Region 2
Traffic & Safety | Access Permits
5615 Wills Blvd.
Pueblo, CO 81008-2349

April 15, 2021

RE: D Johnson Minor Subdivision
EA2075 MS211 | 4 lot minor subdivision

JOHNSON ESTATES FILING NO. 1

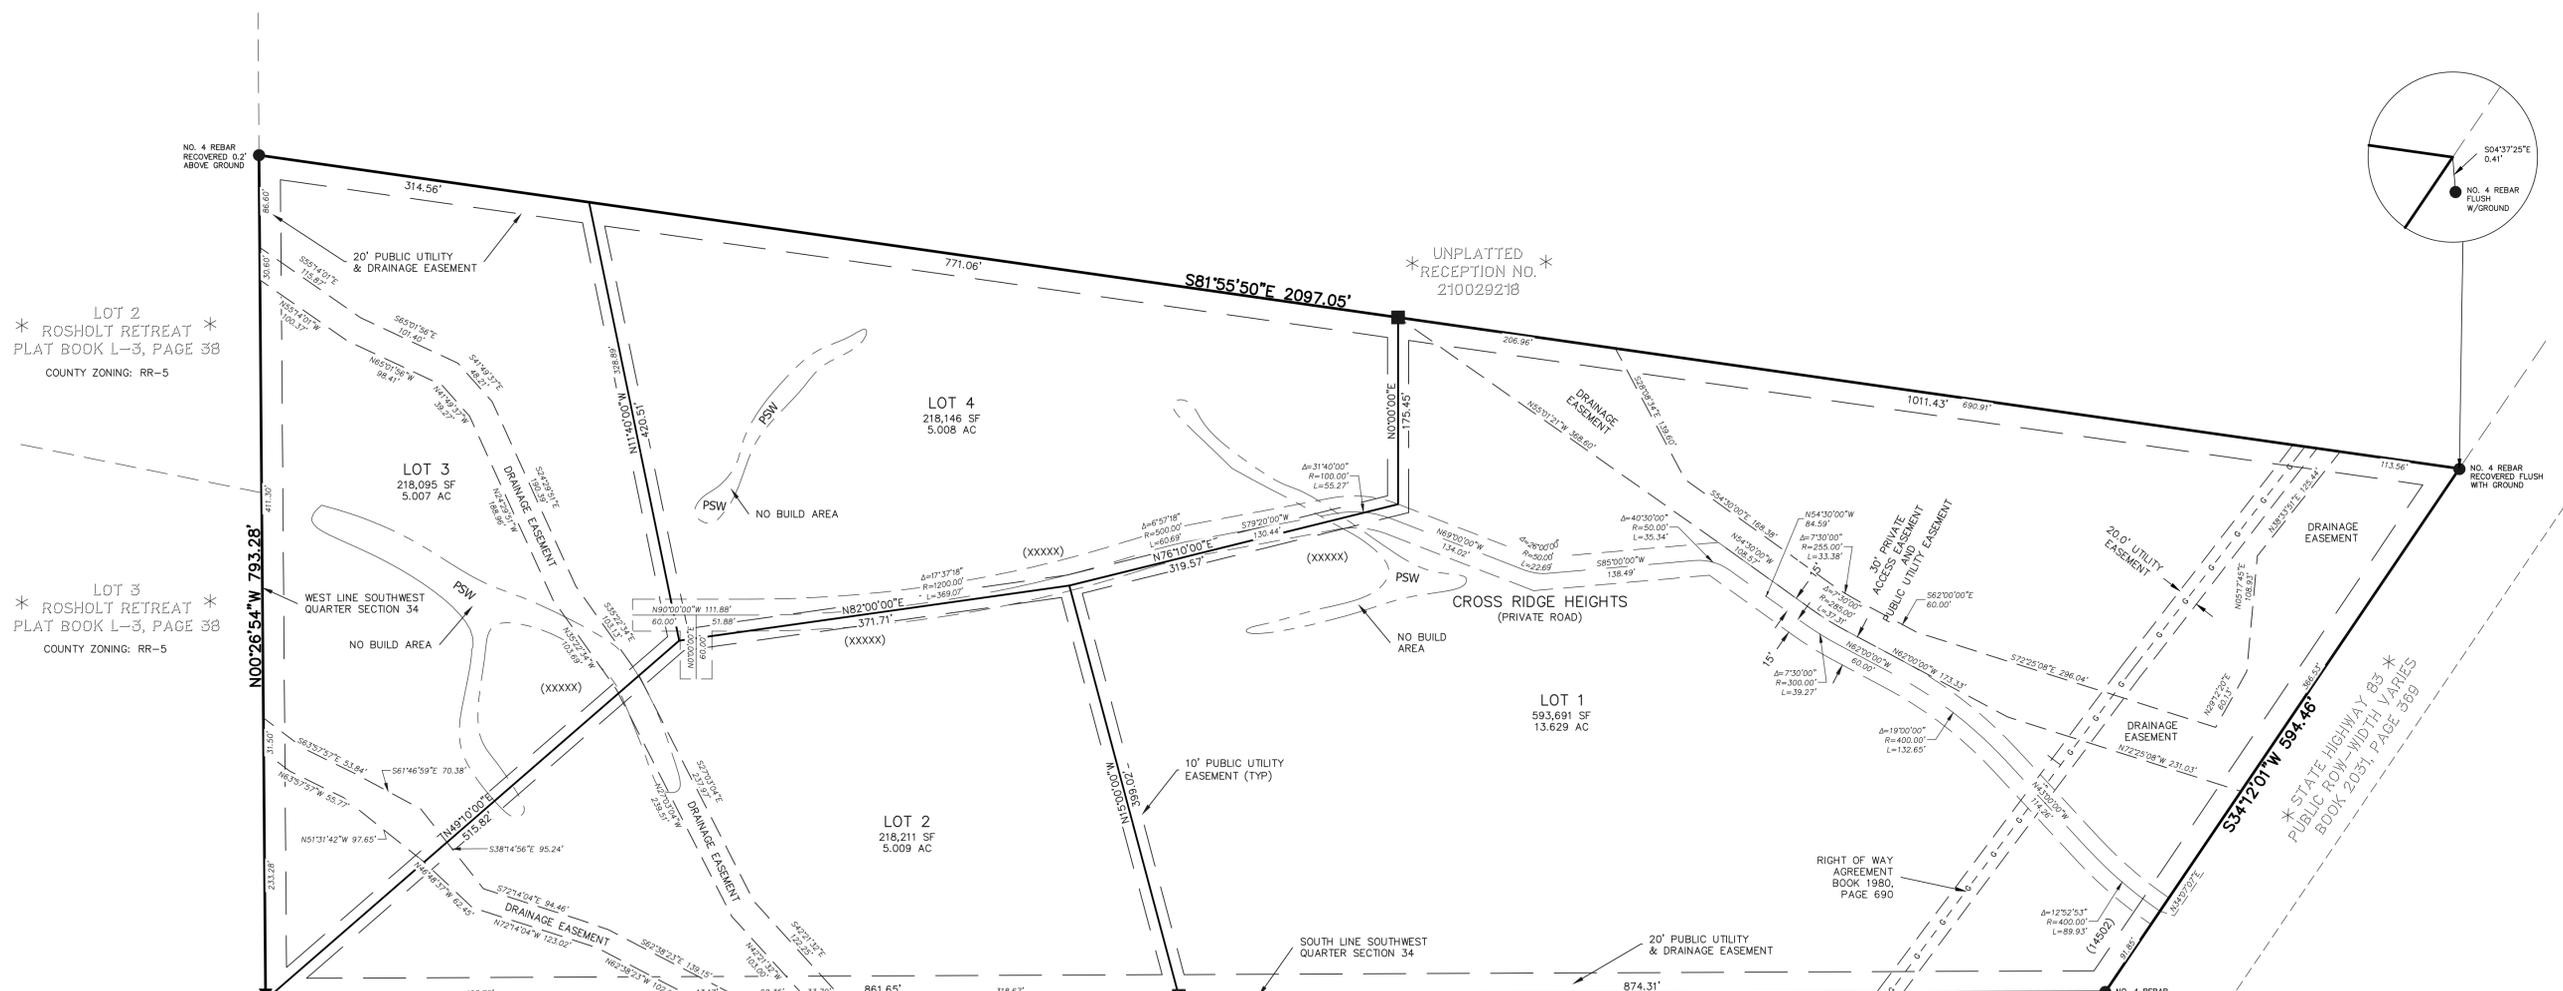
- Since the original submission of the Access Permit CDOT, the City of Colorado Springs and El Paso County has begun the process of establishing an Access Control Plan for SH83. As such, CDOT requests that the private access easement be extended to and tie in with Old Lasso Point and that cross lot access easements be platted to provide vehicular access to the two lots directly south of Lot 1.

- Please respond to traffic and hydraulic comments.
- Access Permit 220062 was issued in July 2020. However, the establishment of easements would modify the traffic using the access and should be captured by a new CDOT Access Permit.
